From: Philip Trueman <ptrueman@hesterarchitects.co.uk>
Sent: 23 July 2021 09:17
To: Richard Phillips
Subject: RE: Morrisons, 41-67 High Street, Yiewsley - 2370/APP/2021/67
Attachments: NBS Yiewsley hard landscape works 08.03.21.pdf; 0811.1.2 YIEWSLEY PLANTING PLAN GROUND FLOOR LEVEL 08.03.21.pdf; 0811.1.4 YIEWSLEYGROUND FLOOR HARD LANDSCAPE 08.03.21.pdf; 0811.1.5 YIEWSLEY PLAY AREA 08.03.21.pdf; 16128 - 530C - Proposed Materials.pdf; 0811.1.1 REV A YIEWSLEY PLANTING PLAN - DECK LEVEL 22.07.21.pdf; 0811.1.3 REV A YIEWSLEY HARD LANDSCAPE DECK LEVEL 22.07.21.pdf; 0811.1.6 REV A YIEWSLEY LANDSCAPE DETAILS 22.07.21.pdf; NBS Yiewsley Soft landscape specification Rev A 22.07.21.pdf; YIEWSLEY LANDSCAPE MANAGEMENT PLAN REV A 22.07.21.pdf; 16128 - 2 - 630 - Privacy Screen Details.pdf; 16128 - 2 - 631 - Podium Privacy Screen Details.pdf; 16128 - 743 - Balcony Privacy Screen - Details.pdf

CONDITION 5: Materials and external surfaces (ref. 2019/2880)

CONDITION 7: Landscape scheme (ref. 2018/2793)

Drawn by RI	Date 23/12/20	Checked PT
Job No. 16128	Drawing No. 2 - 910	Rev. A

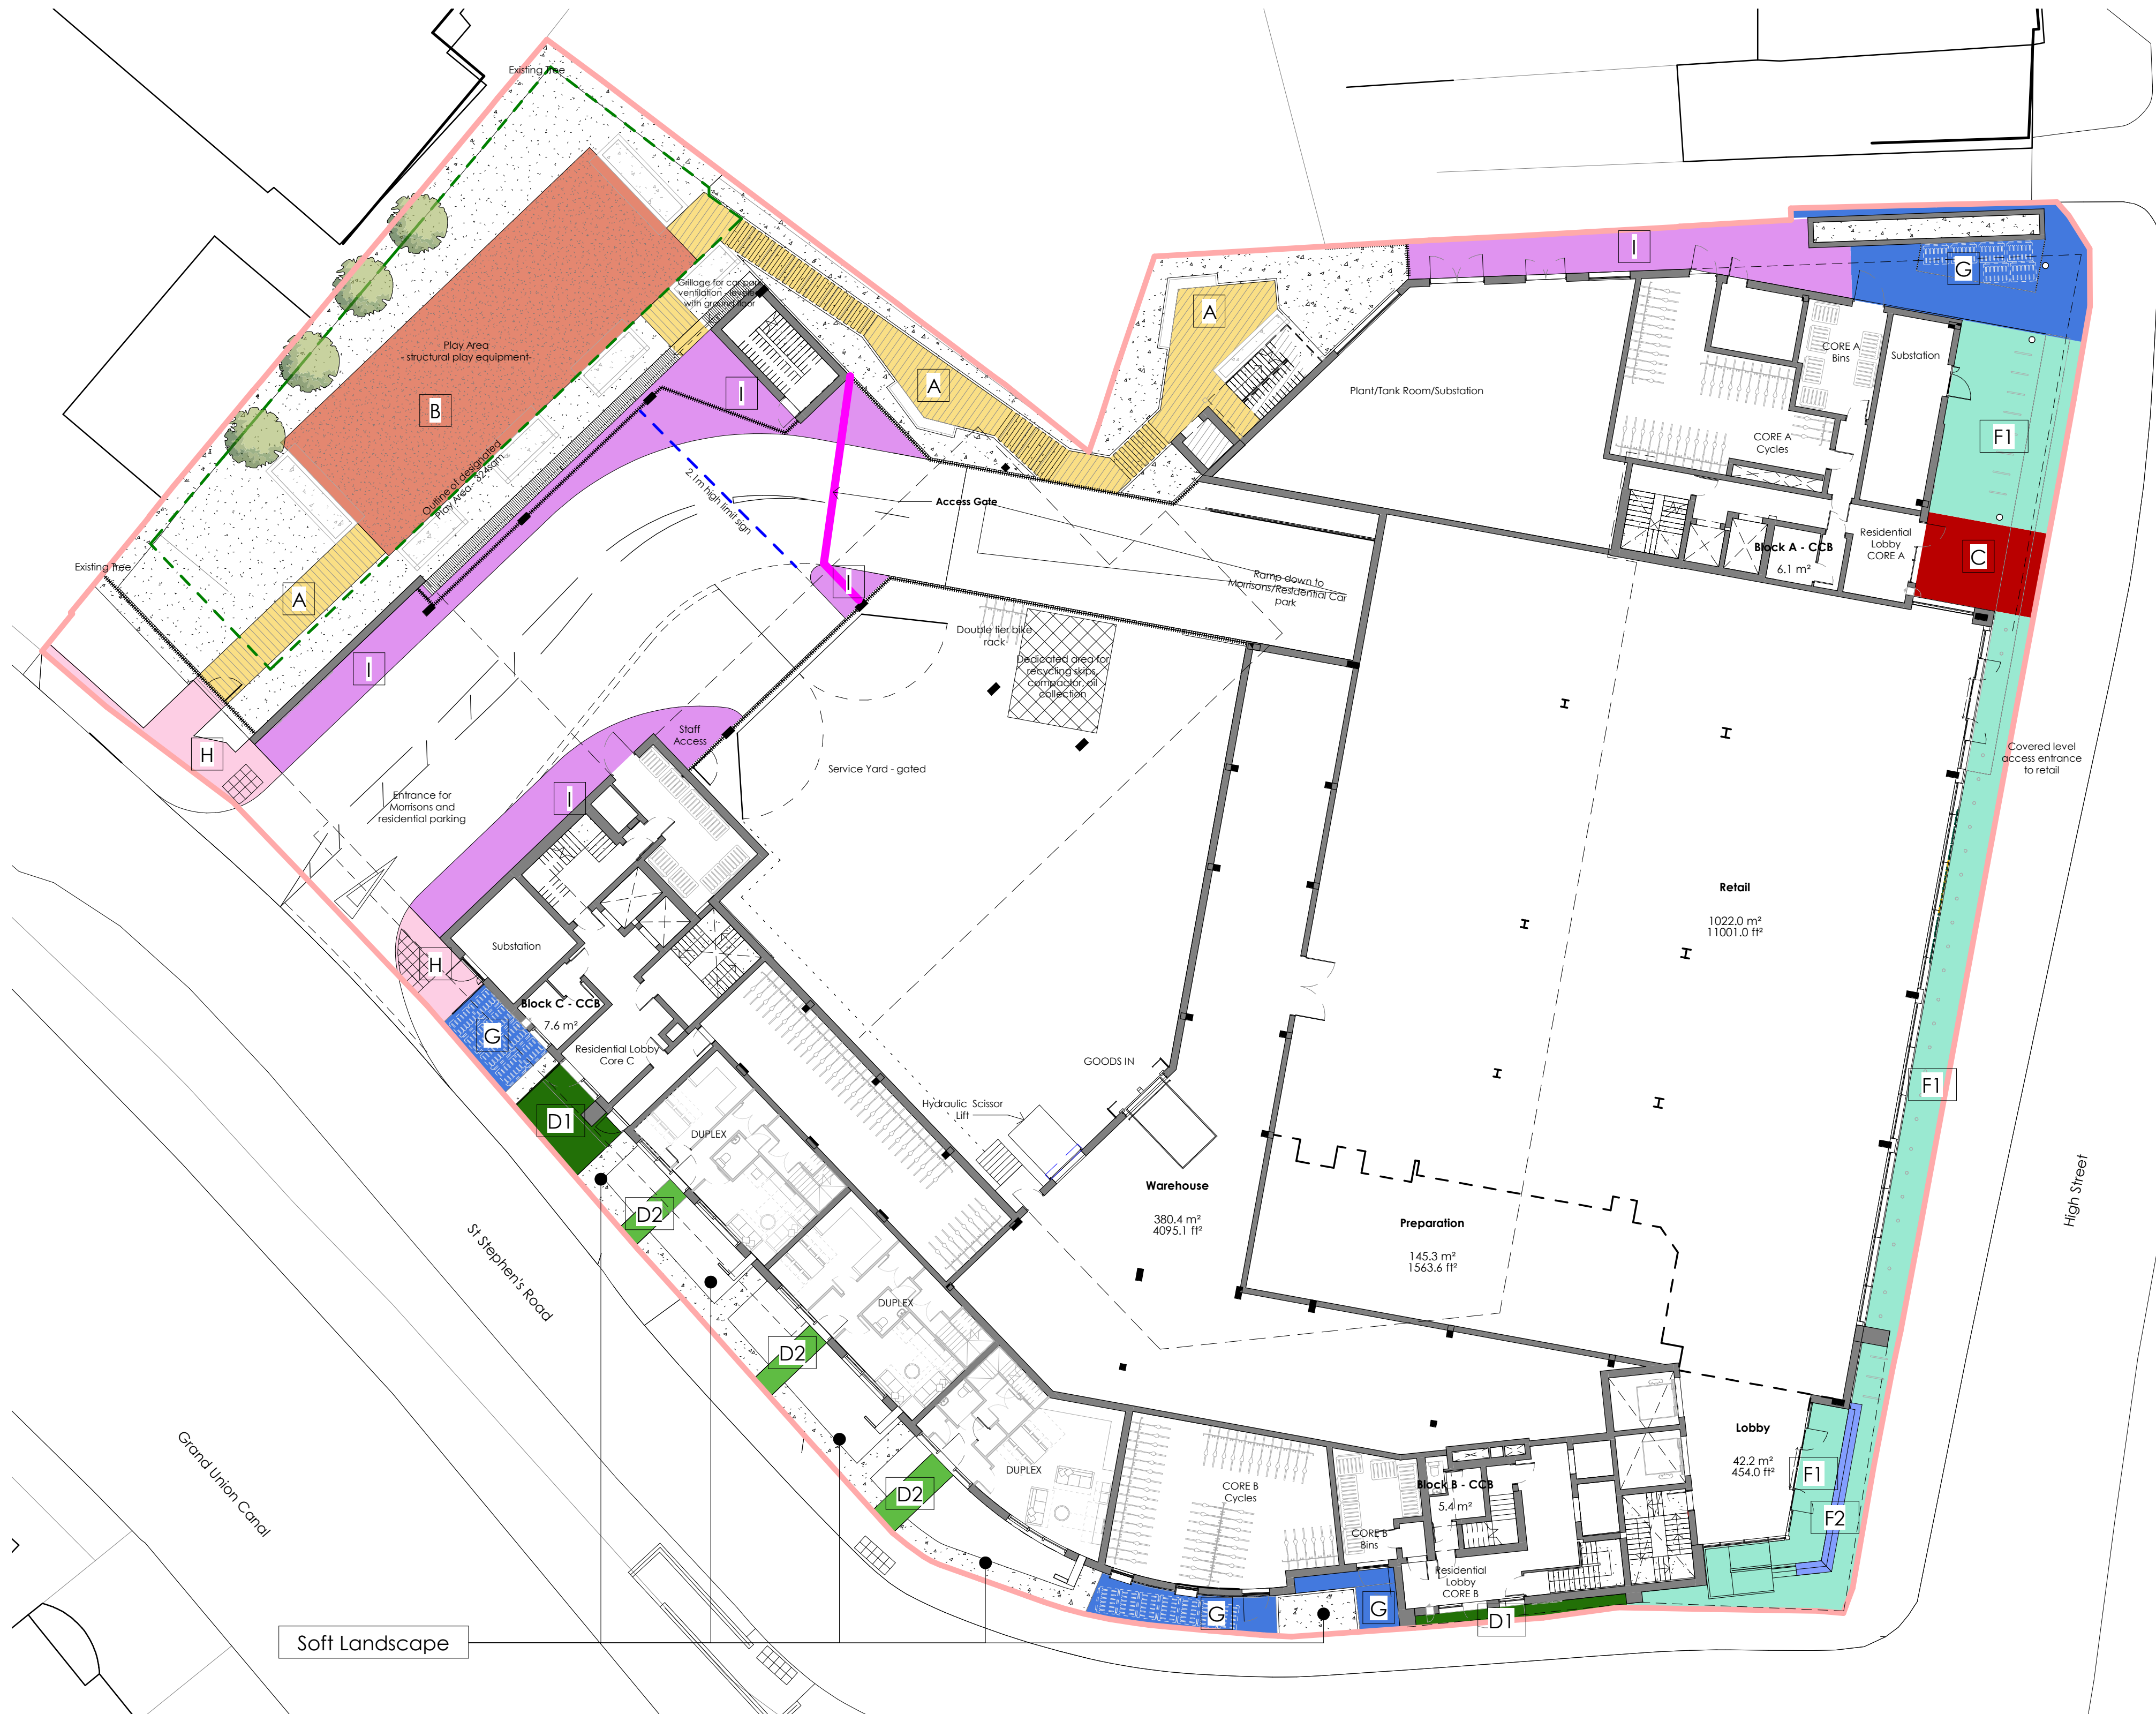
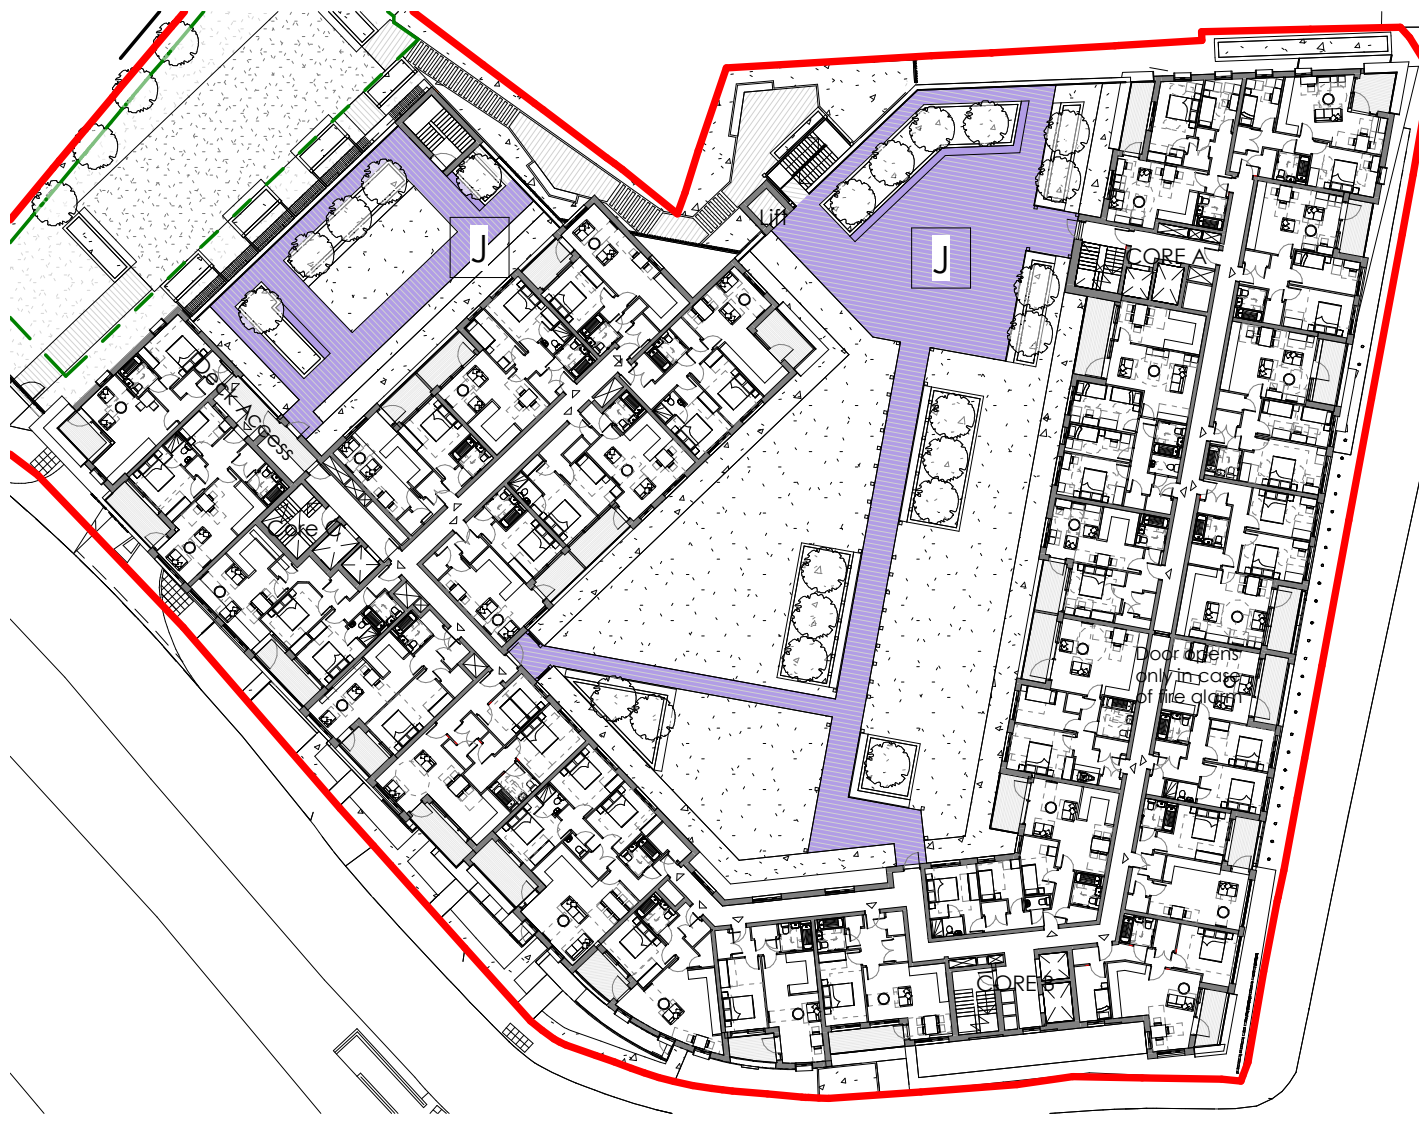
Hester drawing 2-910 Rev A provides a plan with colour-coded hard surfacing. The last item on the schedule is J (Deck paving) - no deck paving is indicated on plan.

Clarification is required regarding the whereabouts of the deck paving on site? No information available regarding the external walls / boundary treatments.

The Type J deck paving is used on the upper amenity deck – please see attached – **Yiewsley Hard Landscape Deck Level.**

In reviewing the materials submission we have noticed that one of the RAL references is incorrect – as below – so we have attached a revised drawings **16128 - 530C Proposed Materials** to correct this.

**1 Balcony Privacy Screen - Plan**  
1 : 10

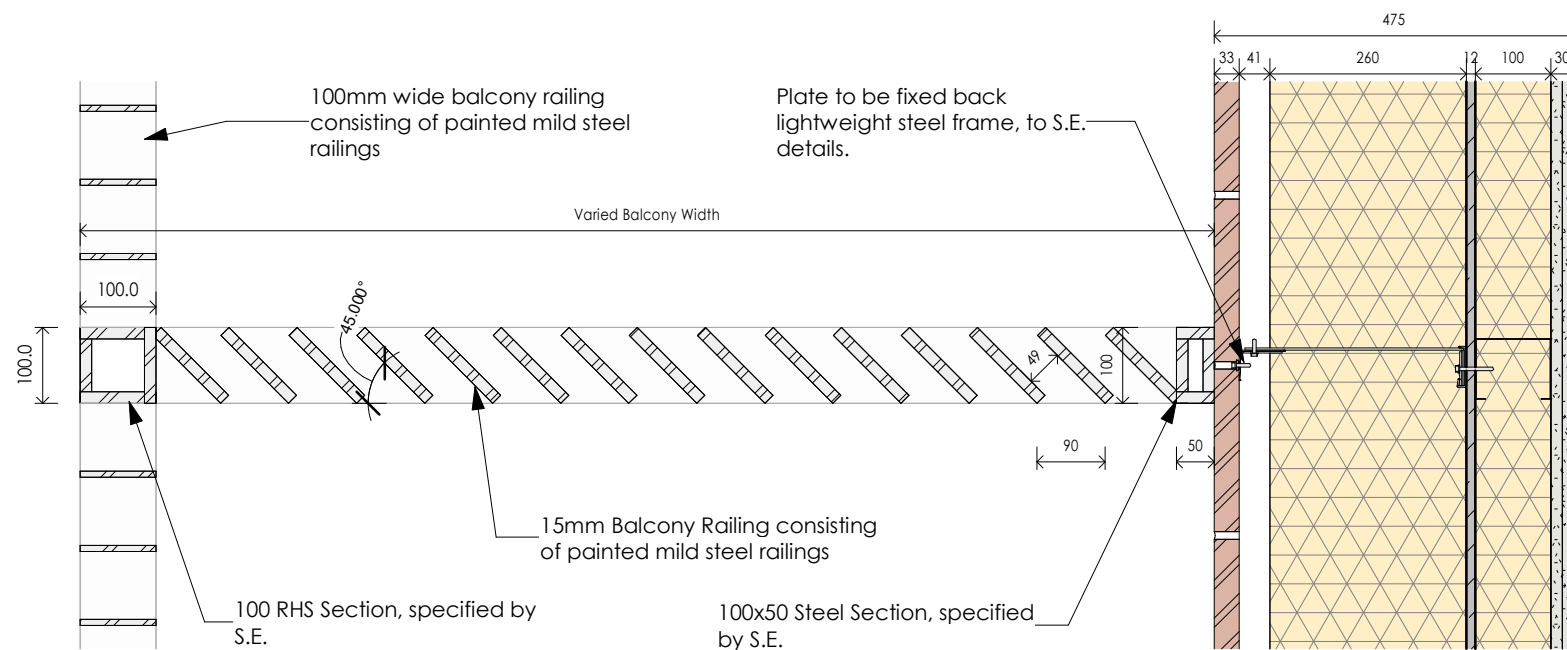
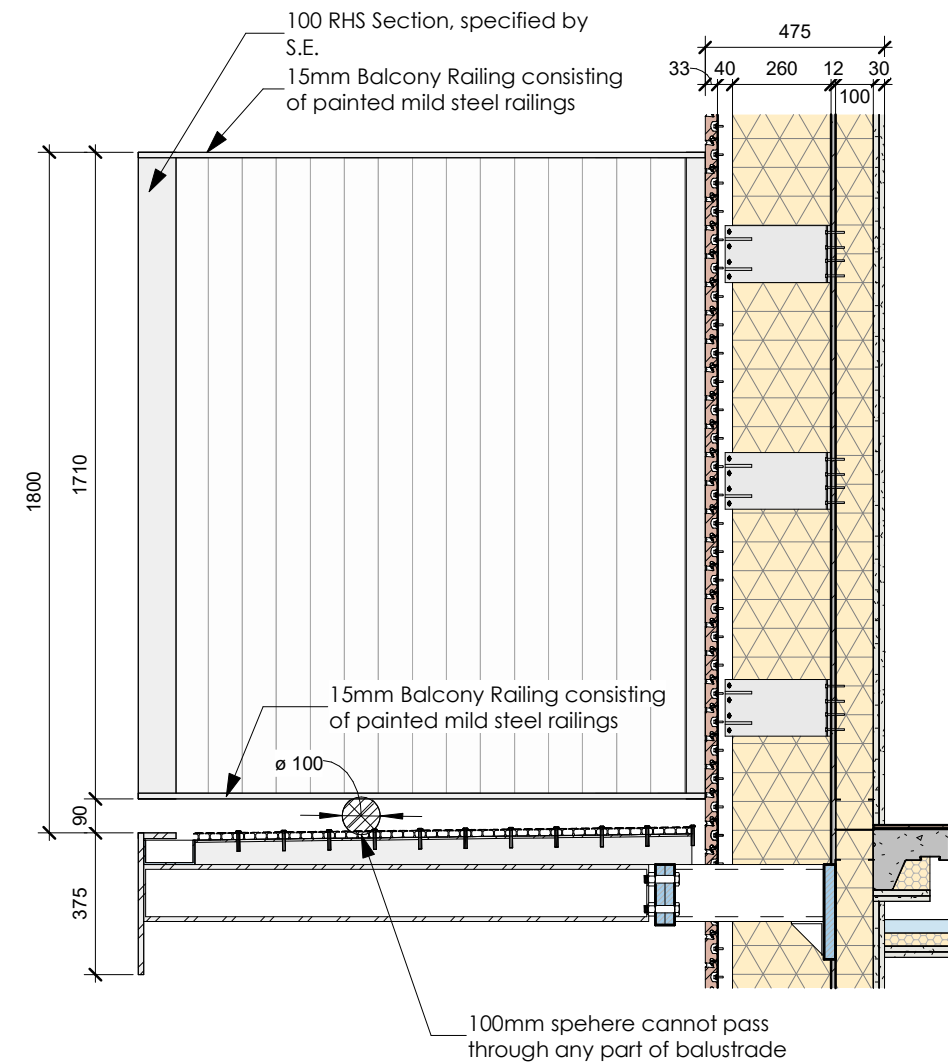
Condition 10 – Privacy Screens

I have attached revised drawings for the Privacy Screens which removes the 45 degree bars in favour of a simple powder coated aluminium screen which should address any concerns about over-looking between properties.

VIEWISLEY PLANTING PLAN 22.07.21

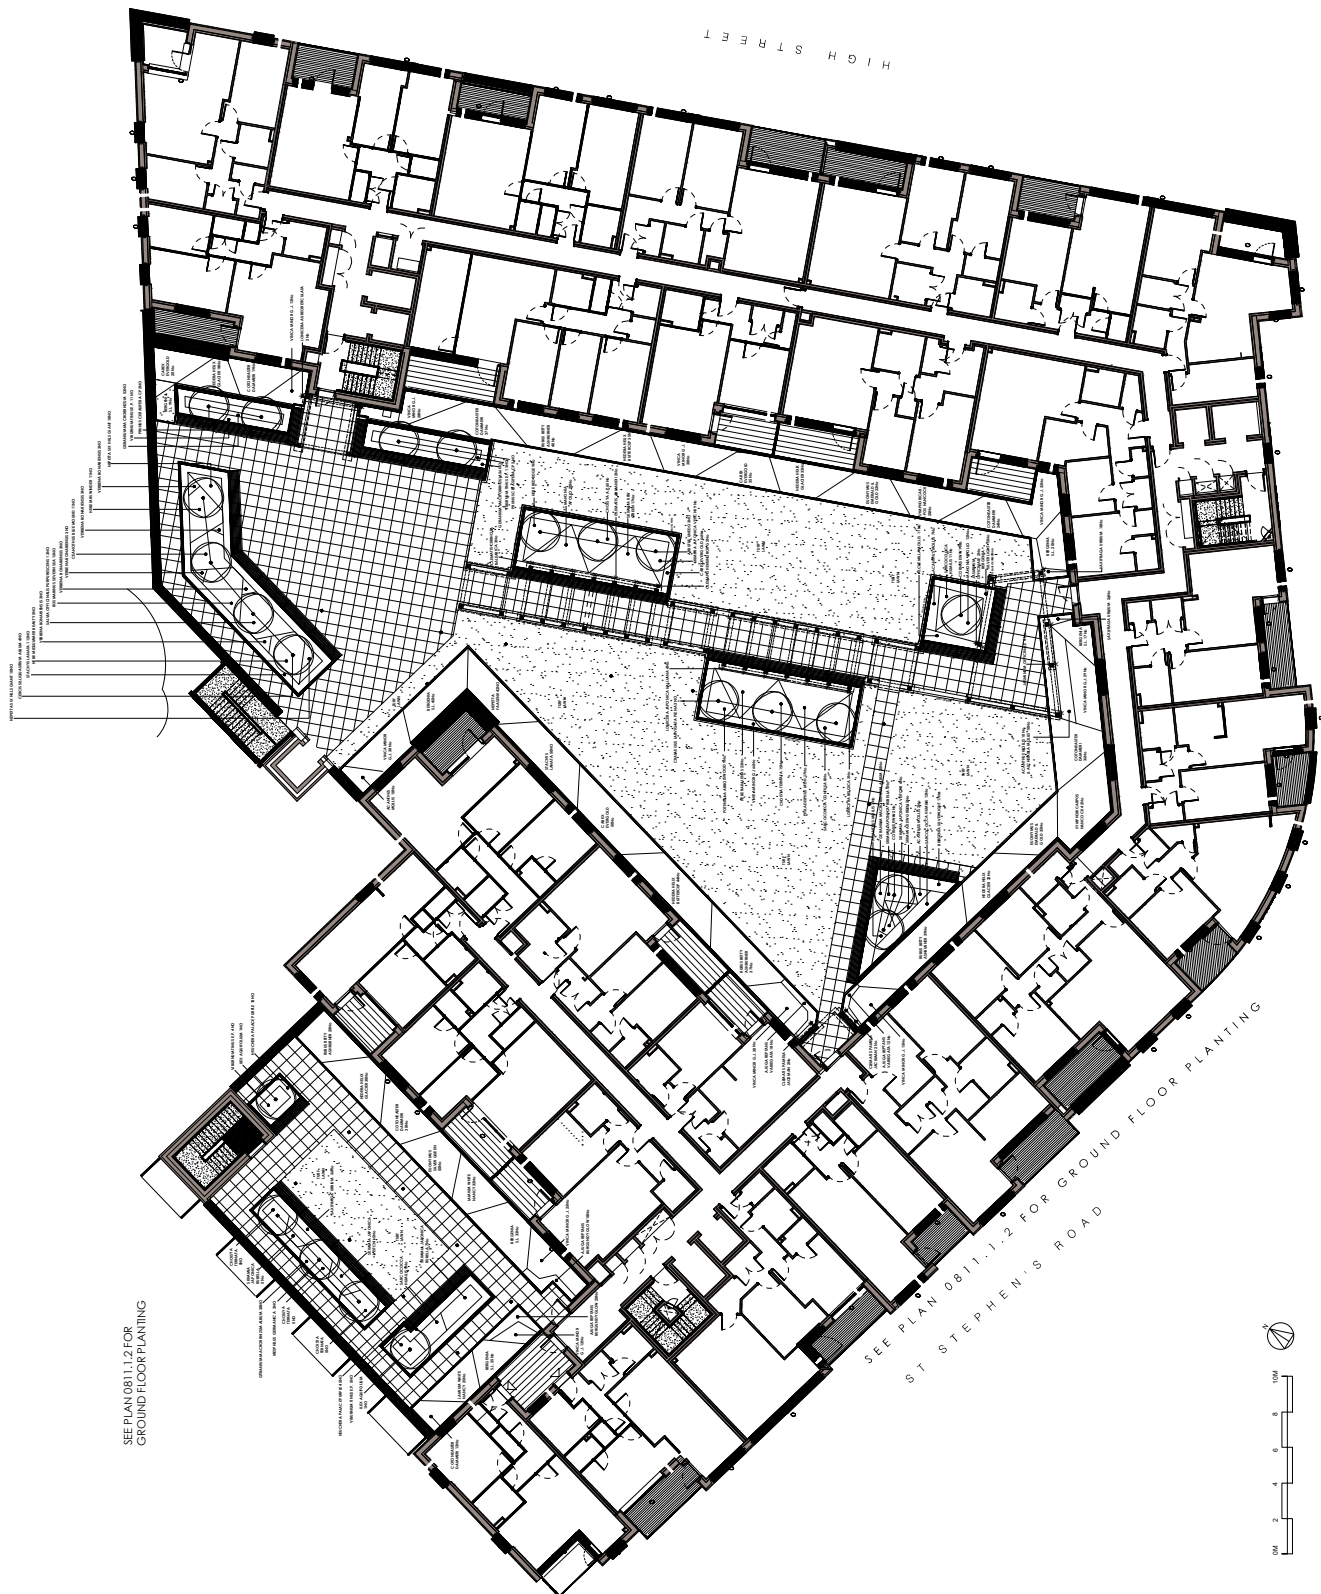
No soft landscape details have been submitted. The drawing submitted under ref. 2370/APP/2018/2793 was a masterplan showing an indicative layout only.

Full landscape details (by a landscape consultant), with detailed plans, schedules, specification of work and a management / maintenance plan are required.

All soft landscaping is shown and specified on the submitted documents. I have re-attached these for ease of reference as it seems the landscape officer has not received them.
